**Washington State
Department of Transportation**

July 21, 2016

Subject: CU-15-00007 – Chimpanzee Sanctuary NW
SR 10 milepost 91.1 right

SITE PLAN

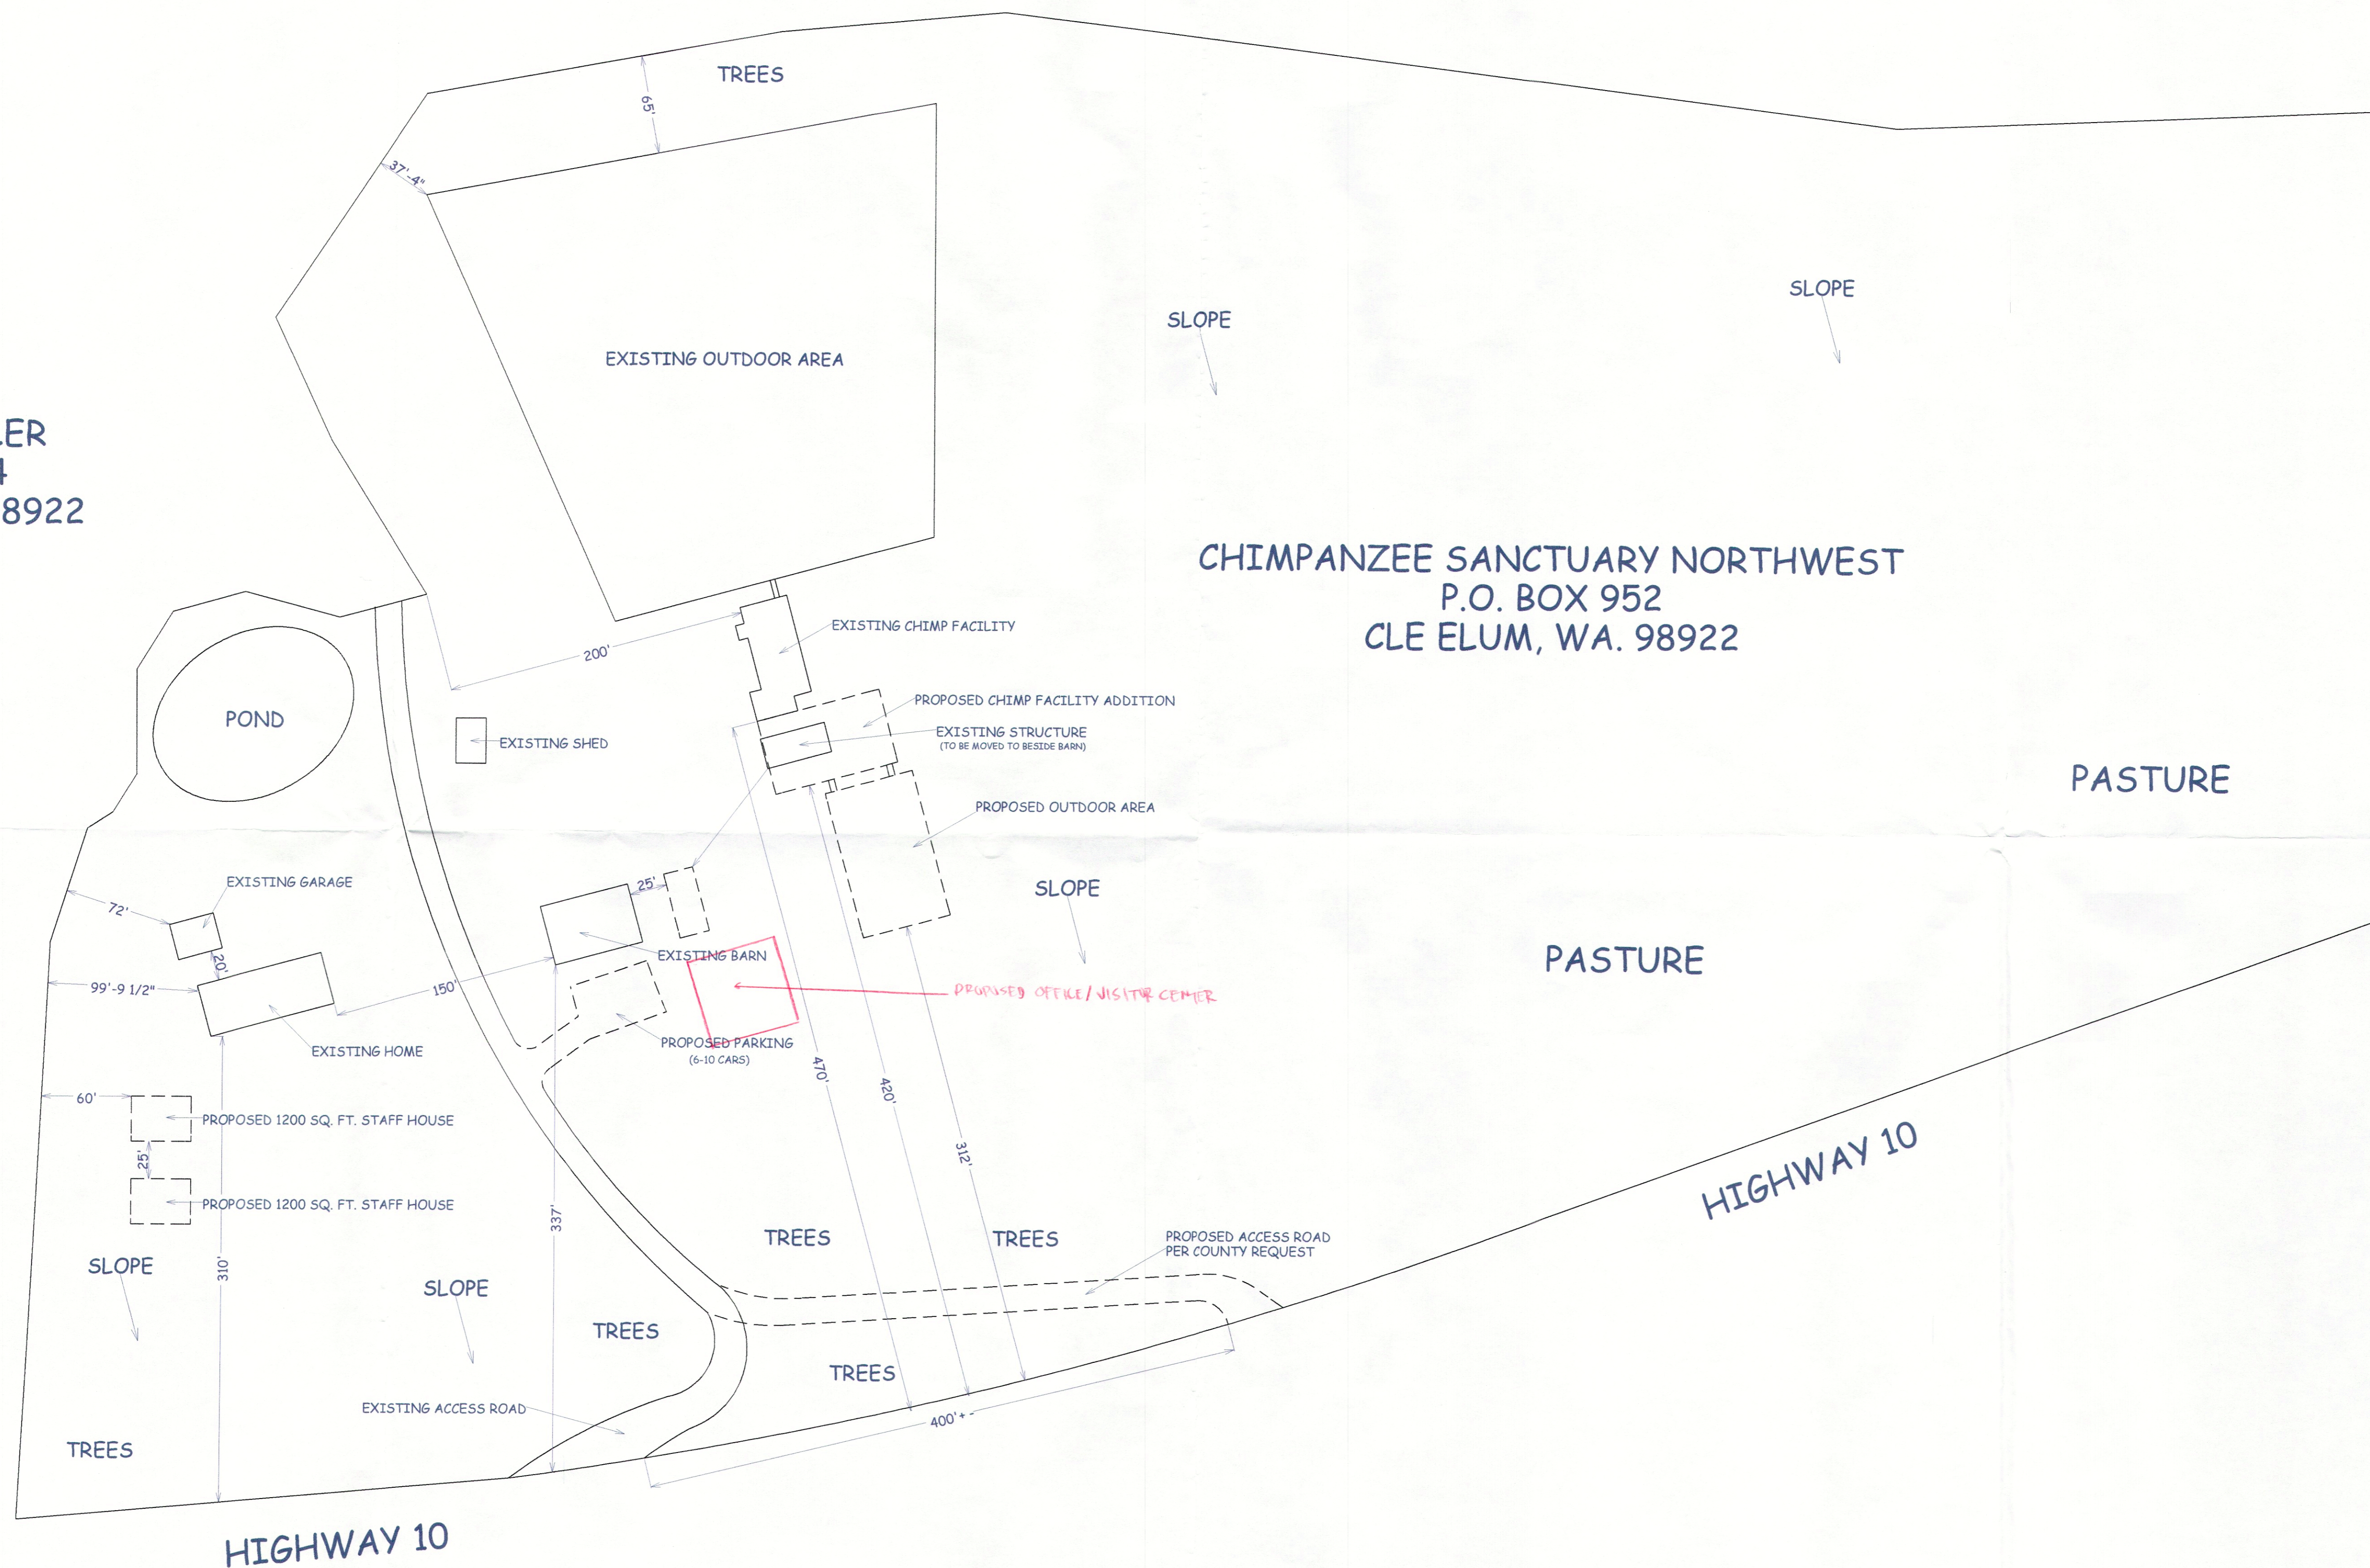
The subject property is adjacent to State Route 10 (SR 10), a managed access Class 3 highway with a posted speed limit of 55 miles per hour. The property has a grandfathered approach at milepost 91.1 right. This location does not provide the minimum required road approach sight distance of 495'. Prior to development approval, the proponent shall construct the new access connection further to the south and remove the existing approach in its entirety.

Kittitas County has just recently supplied us with a map showing the location of the proponent's intended access point. A new Access Connection Permit must be obtained. The property owner is required to contact Mark Kaiser of the WSDOT South Central Region Office at (509) 577-1668 to apply for the permit.
